Subject: RE: Fontwell ref.WA/71/18/DOC.

Fontwell noise report comments:

Figure 4.1: Barrier Calculation (excerpt from proprietary Pace Consult barrier calculation sheet)

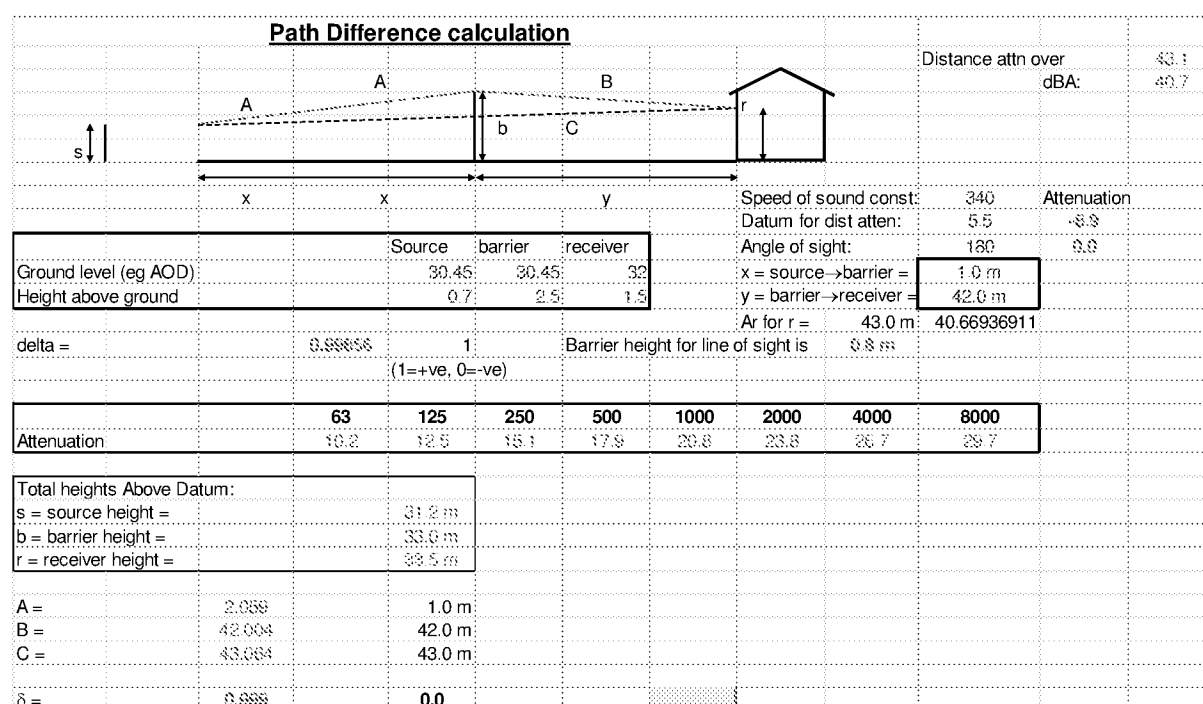
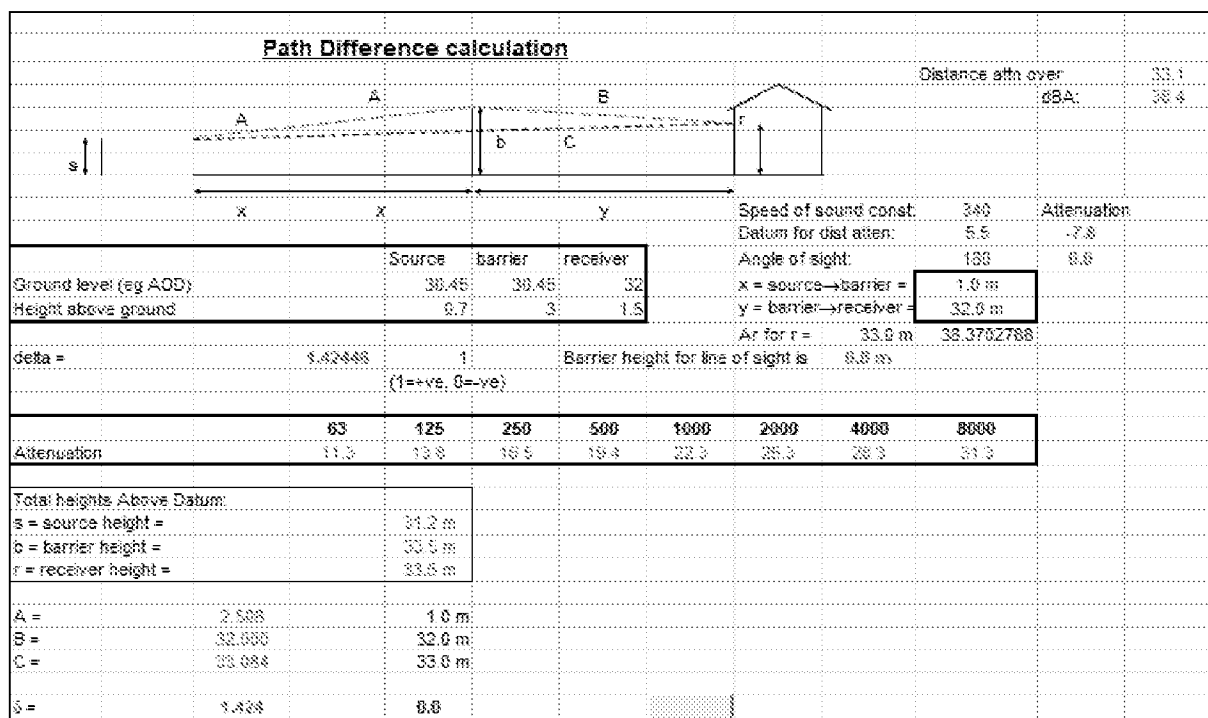
8. With regard to the acoustic barrier, the residential properties to the north and west of the site are located higher than properties to the south. We have concerns therefore that the barrier would not prove as effective as the applicant may have intended.

8. As long as the barrier obstructs the direct line of sight between the equipment and the noise sensitive receptors (which it does by far) then noise will be reduced. We are confident that the fence will provide adequate attenuation.

In order to provide sufficient air flow around the units the layout has been slightly amended and to assist in omitting the allowance for vegetation, it is proposed to increase the height of fence from 2.50 to 3.00m and this forms part of the revised report which supersedes that previously submitted.

Figure 4.2: Noise barrier location.

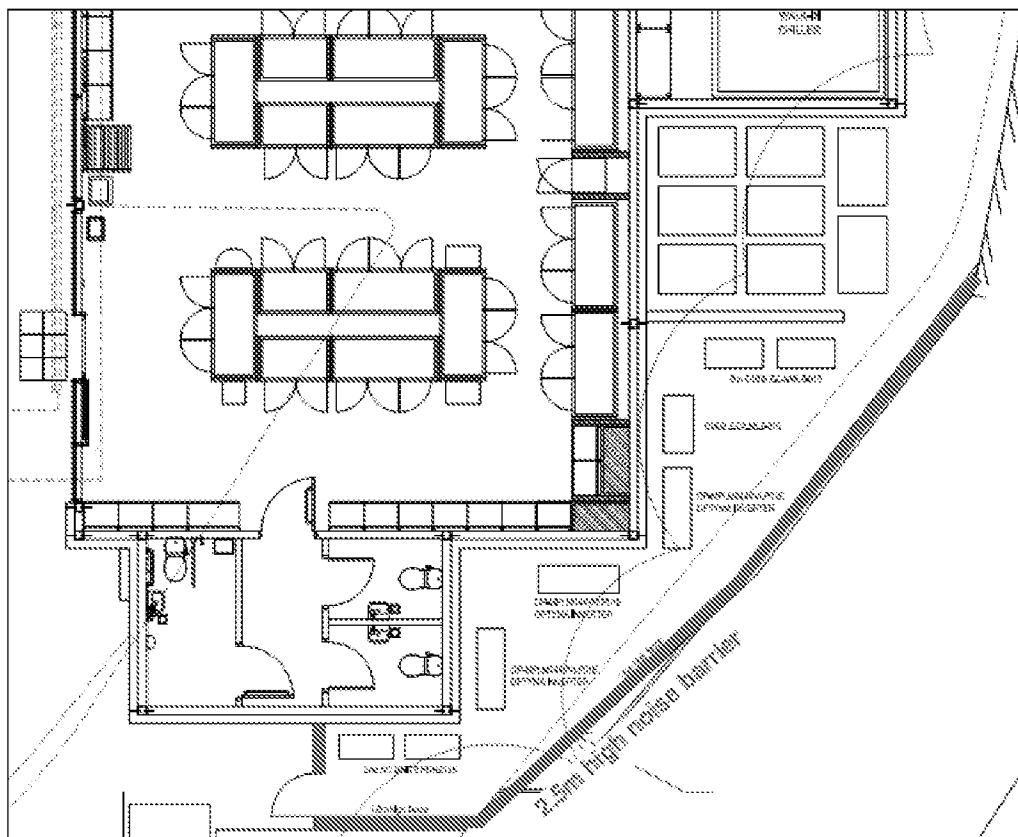
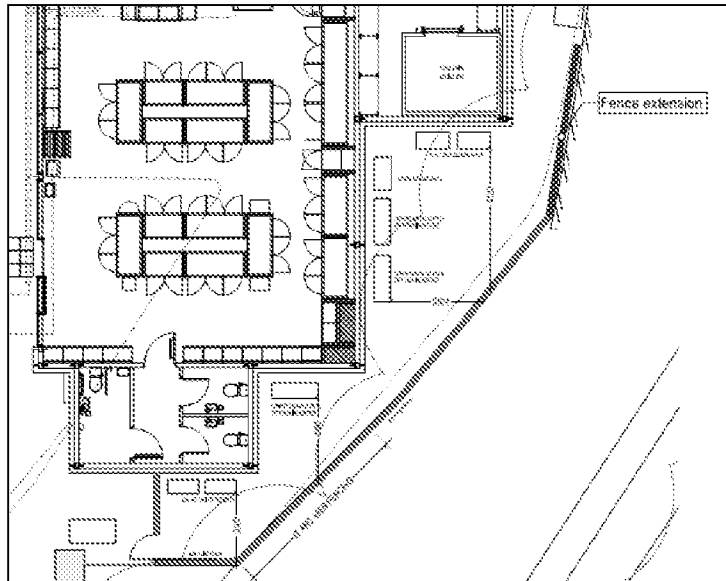
7. Please could the applicant provide the specific location of the acoustic fence. We note that this is shown in Figure 4.2 on page 11 but it is not clear how this ties in with retaining wall in this location.

6. Sound pressure levels produced by this unit are considered to be negligible by our noise consultant.
7. The acoustic fence will overlap and abut the brick retaining wall and be extended along the top of the wall as illustrated in the attached revised report. There will be no gaps in the fence or between the fence and wall.
